Application Comment Report

Application No. ANEX-23-0021

Description : A request for annexation of 6 lots and a portion of Apaloosa Way, comprising of 32.001 acres.

Address : 5340 APALOOSA DR COLORADO SPRINGS CO 80923

ANNEXATION PLAT
TEMPLETON GAP DEVELOPMENT

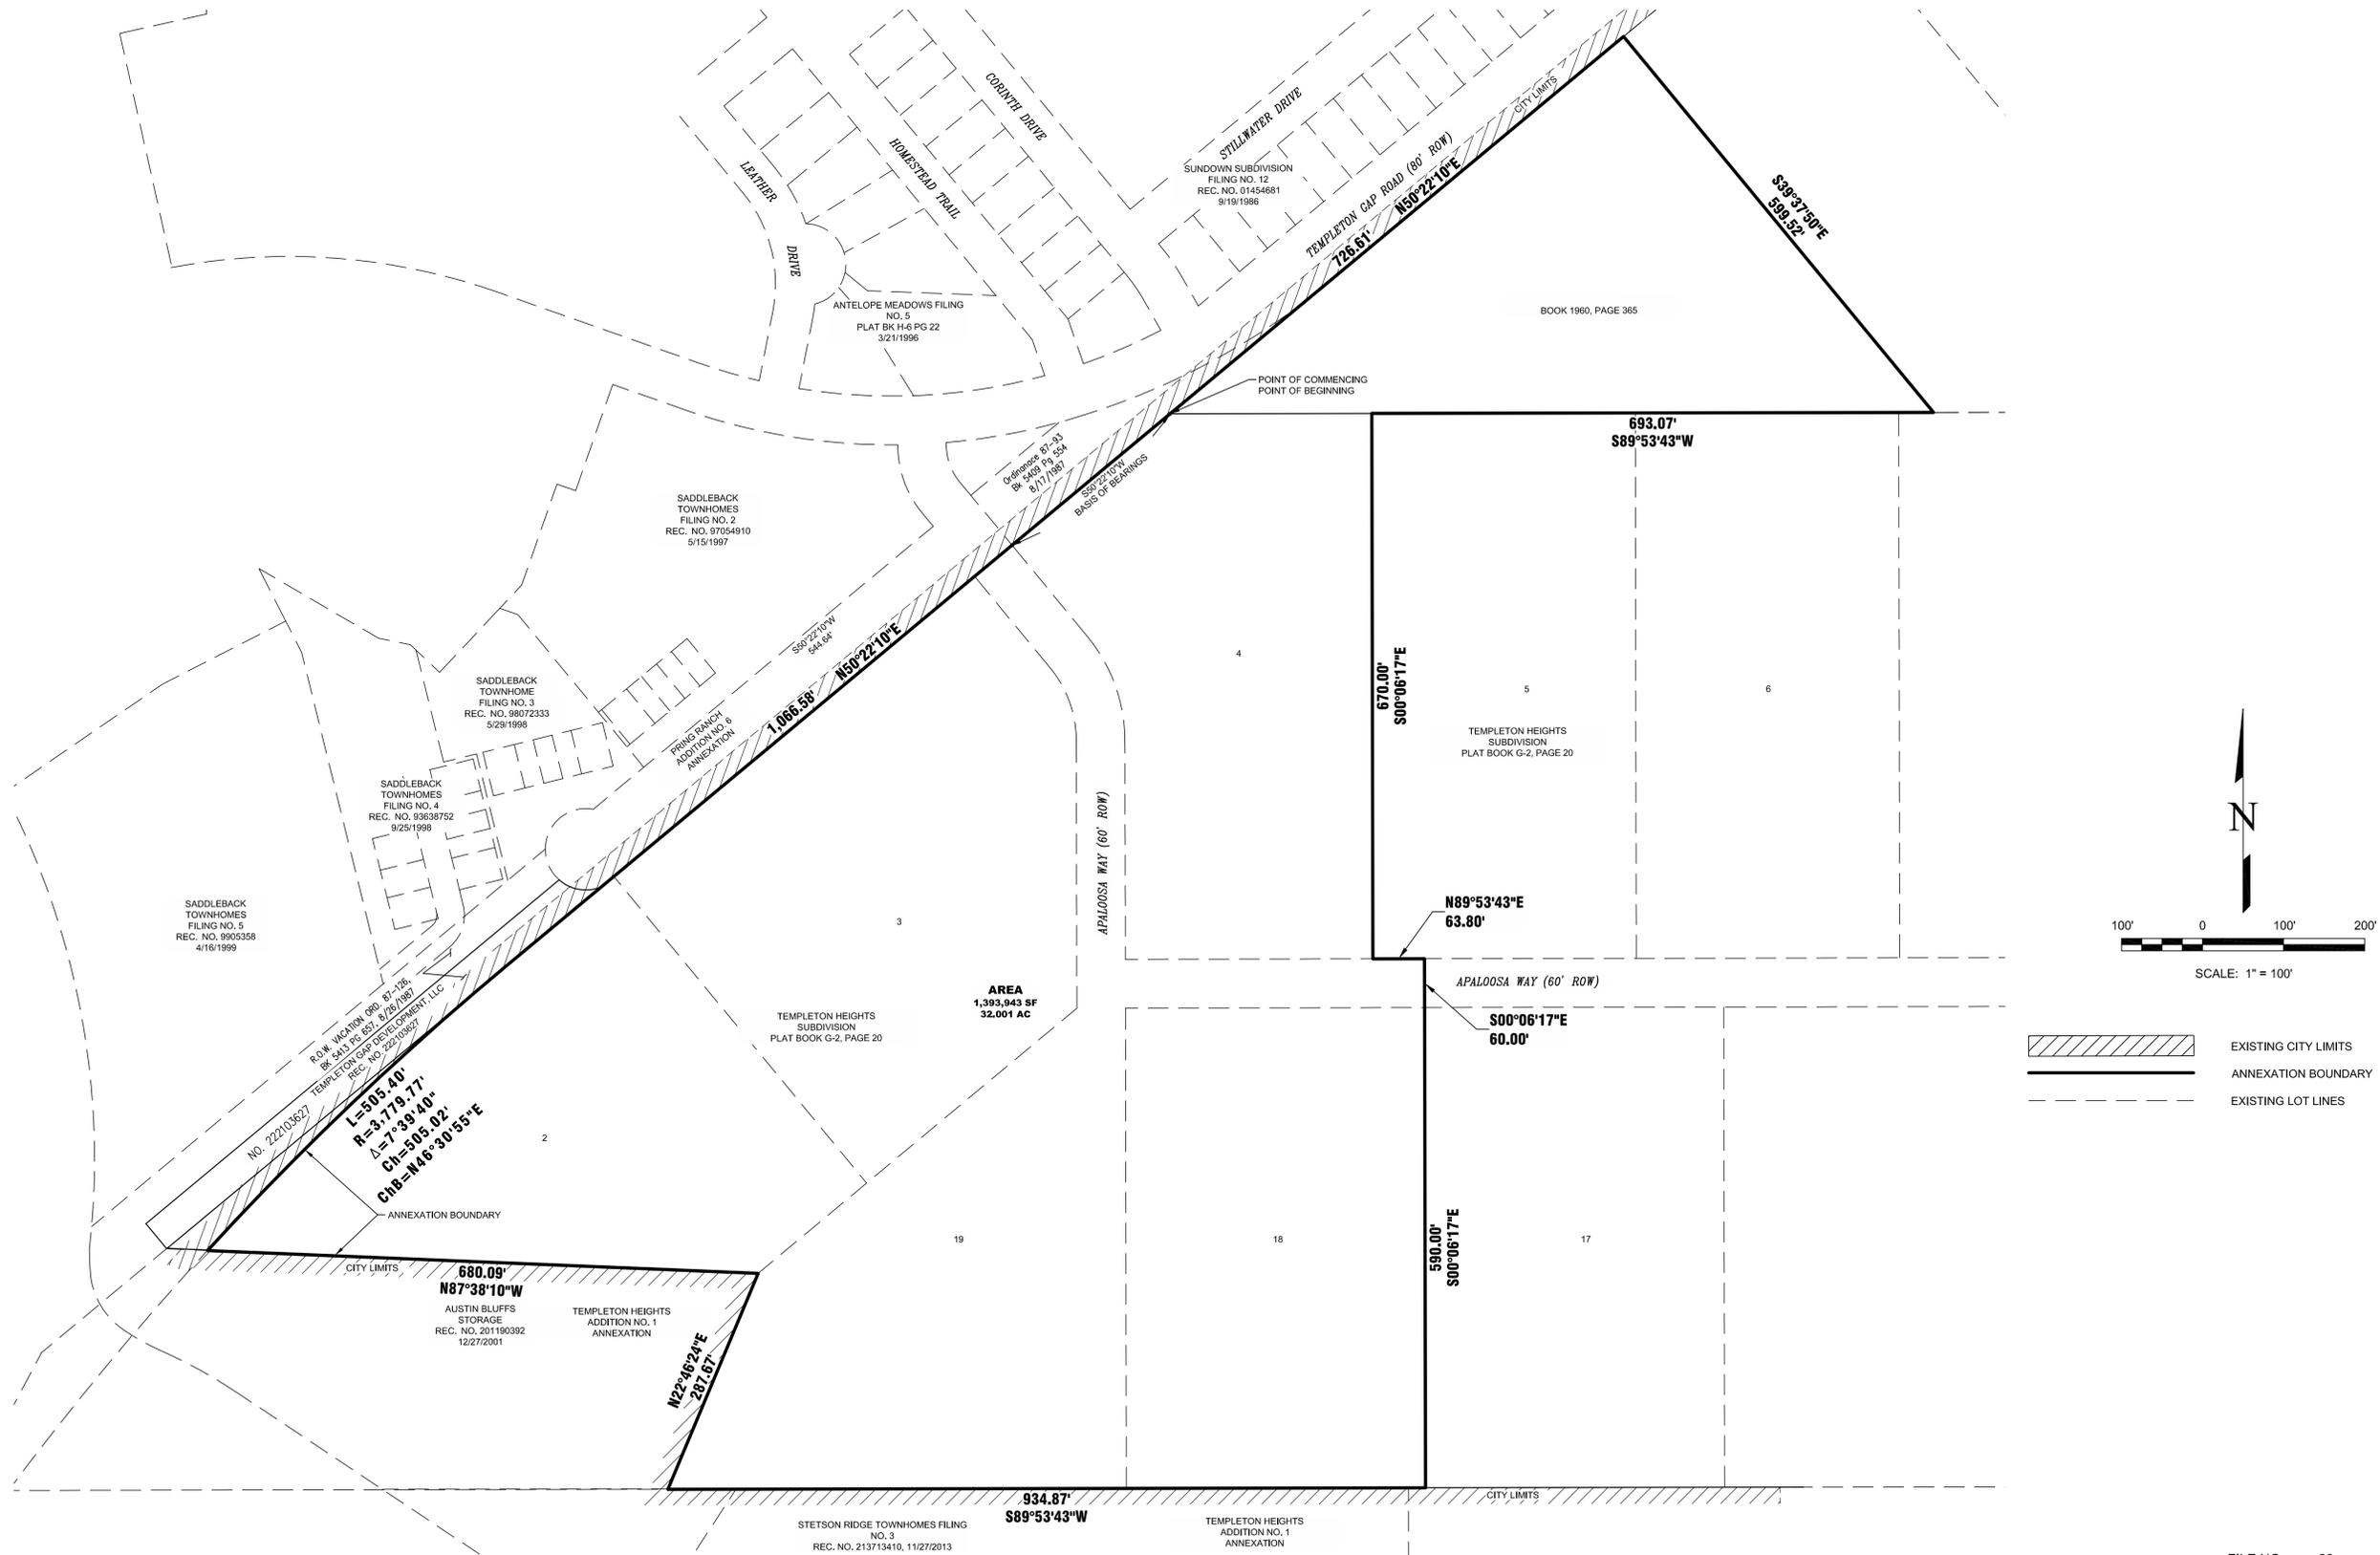
Comment ID	Page Reference	Annotation Type	Reviewer : Department	Status	Review Comments	Applicant Response Comments
4	1	Callout	Cory Sharp : Planning	Closed	Please add a title "Summit View Addition No. 1"

Comment ID	Page Reference	Annotation Type	Reviewer : Department	Status	Review Comments	Applicant Response Comments
5	1	Callout	Cory Sharp : Planning	Closed	Please add sheet 1 of 2	
6	2	Callout	Cory Sharp : Planning	Closed	Please add sheet 2 of 2
